From: Elaine Walby on behalf of Planning.Responses
Sent: 10 March 2026 11:04
To: Planning Scanning
Subject: FW: Re. Planning Application R/31/26/HH. 15 Evelyn Avenue, Rustington, BN16 2EJ

From: [REDACTED]
Sent: 09 March 2026 14:54
To: Planning <Planning@arun.gov.uk>
Subject: Re. Planning Application R/31/26/HH. 15 Evelyn Avenue, Rustington, BN16 2EJ

Gillian Barrett
11 Evelyn Avenue
Rustington
BN16 2EJ

Rev.	Notes	Date
 NAT DESIGN ARCHITECTURAL SERVICES M: 07599199759 E: info@nat-design.co.uk www.nat-design.co.uk		
Project		
15 Evelyn Avenue, Rustington, BN16 2EJ		
Drawing		
Proposed Site & Roof Plans		
Drawn By NSE		Scale as shown
Date Feb 2026		Revision
Drawing No. 2027 -DPA - 02

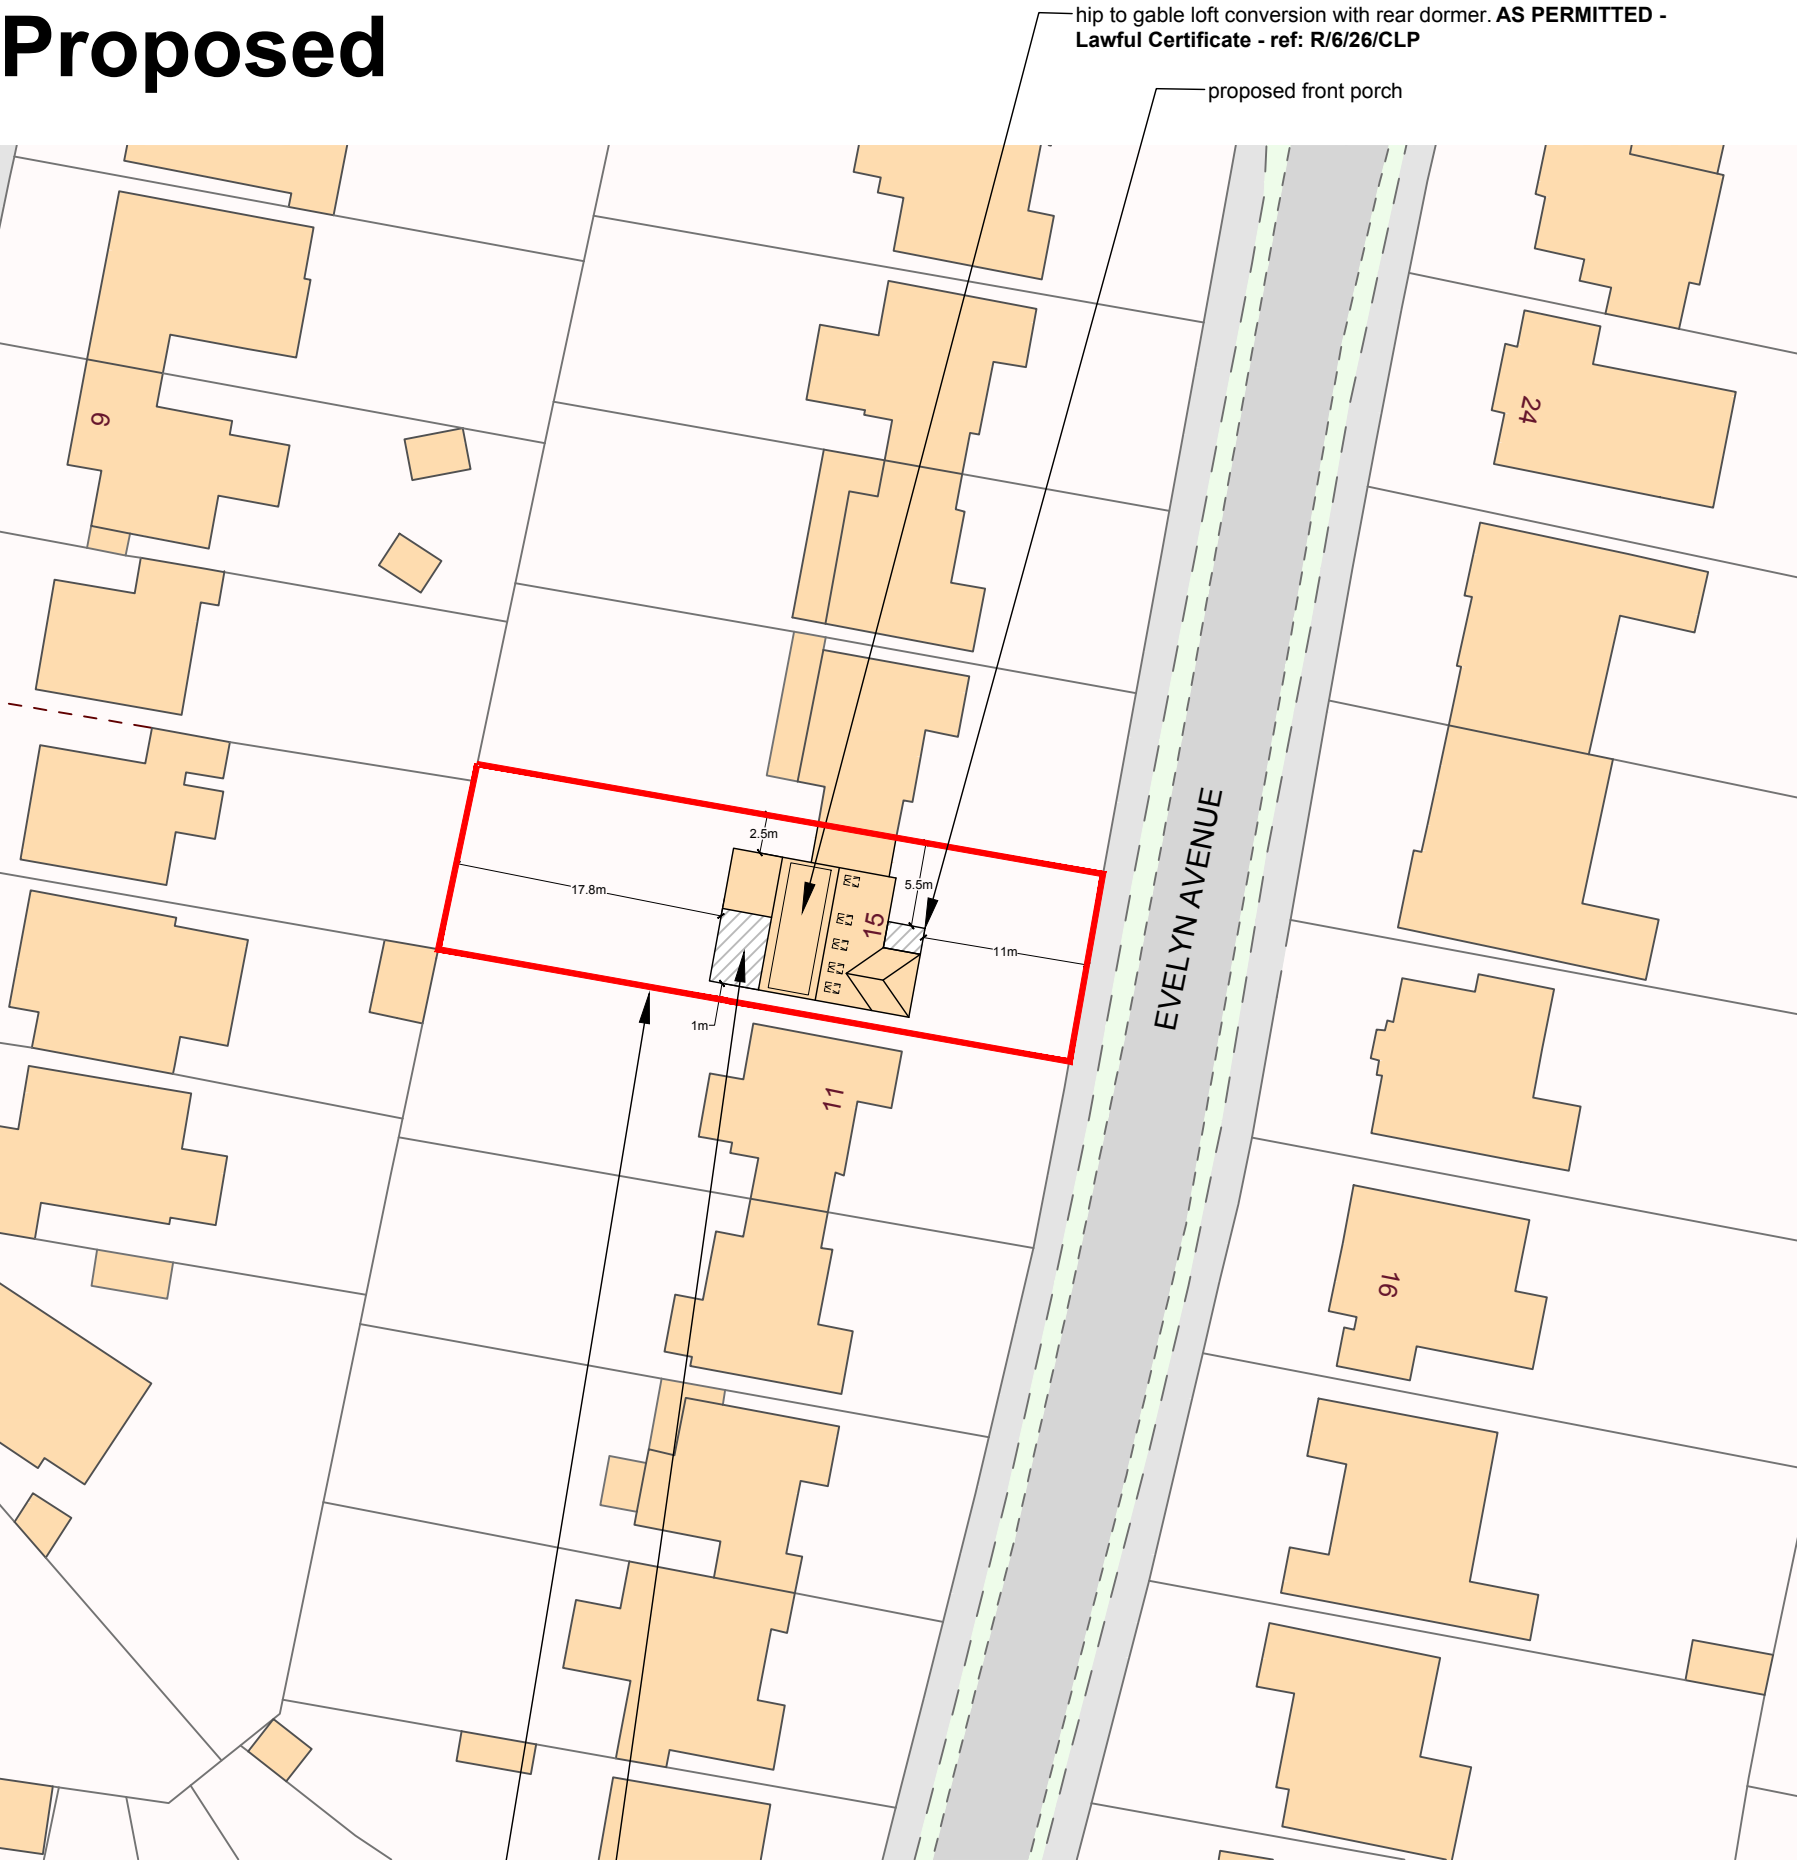
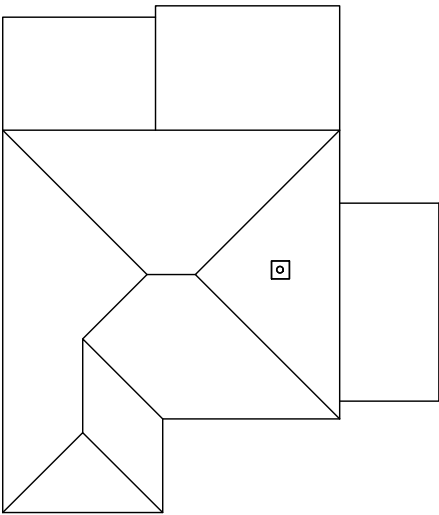
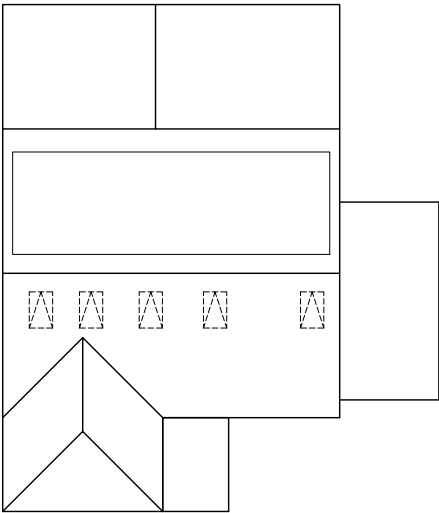
It would be far less intrusive if the dormer could be at the front of the property overlooking the road (where everyone is overlooked anyway) and the five roof lights at the rear. There are already a few front facing dormers in Evelyn Avenue with non intrusive roof lights at the rear.

Rev	Notes	Date
 M: 07599199759 E: info@nat-design.co.uk www.nat-design.co.uk		
Project:		
15 Evelyn Avenue Rustington BN16 2EJ		
Drawing:		
Proposed Elevations		
Drawn by NSE		Scale as shown
Date Feb 2026		Revision
Drawing		
2027 - DPA - 06

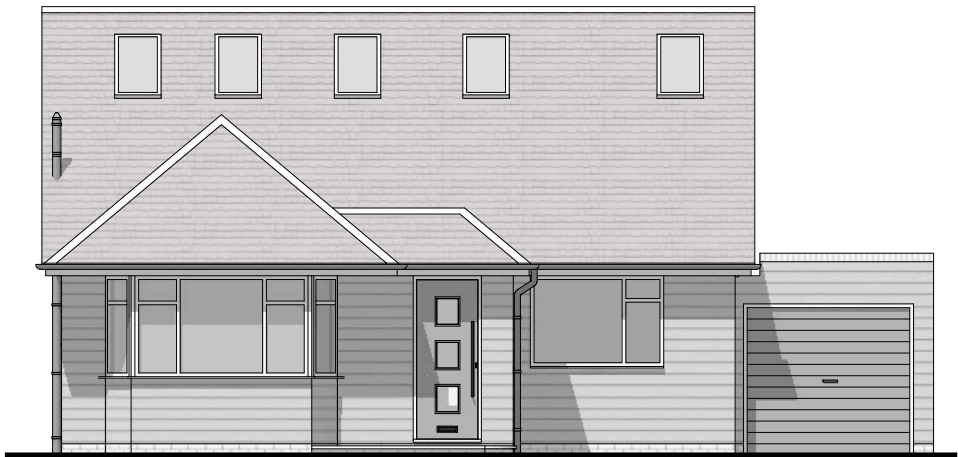
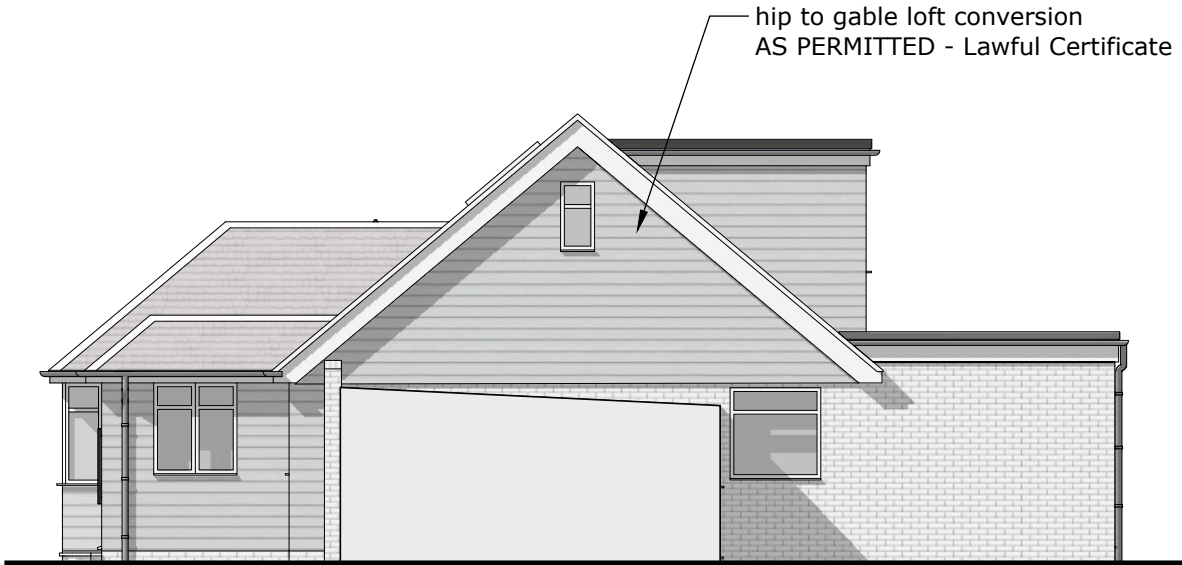
The scale of the development would be very overshadowing and overbearing as my bungalow is only 2 metres apart from this extension. The proposed south facing elevation would greatly impact my north facing windows as the proposed roof gables will be vertical instead of sloping as they are now.

Also, our secluded rear gardens are fairly small, and virtually the whole of my garden will be overlooked, especially as one of the proposed bedrooms at the rear will be very close to my boundary.
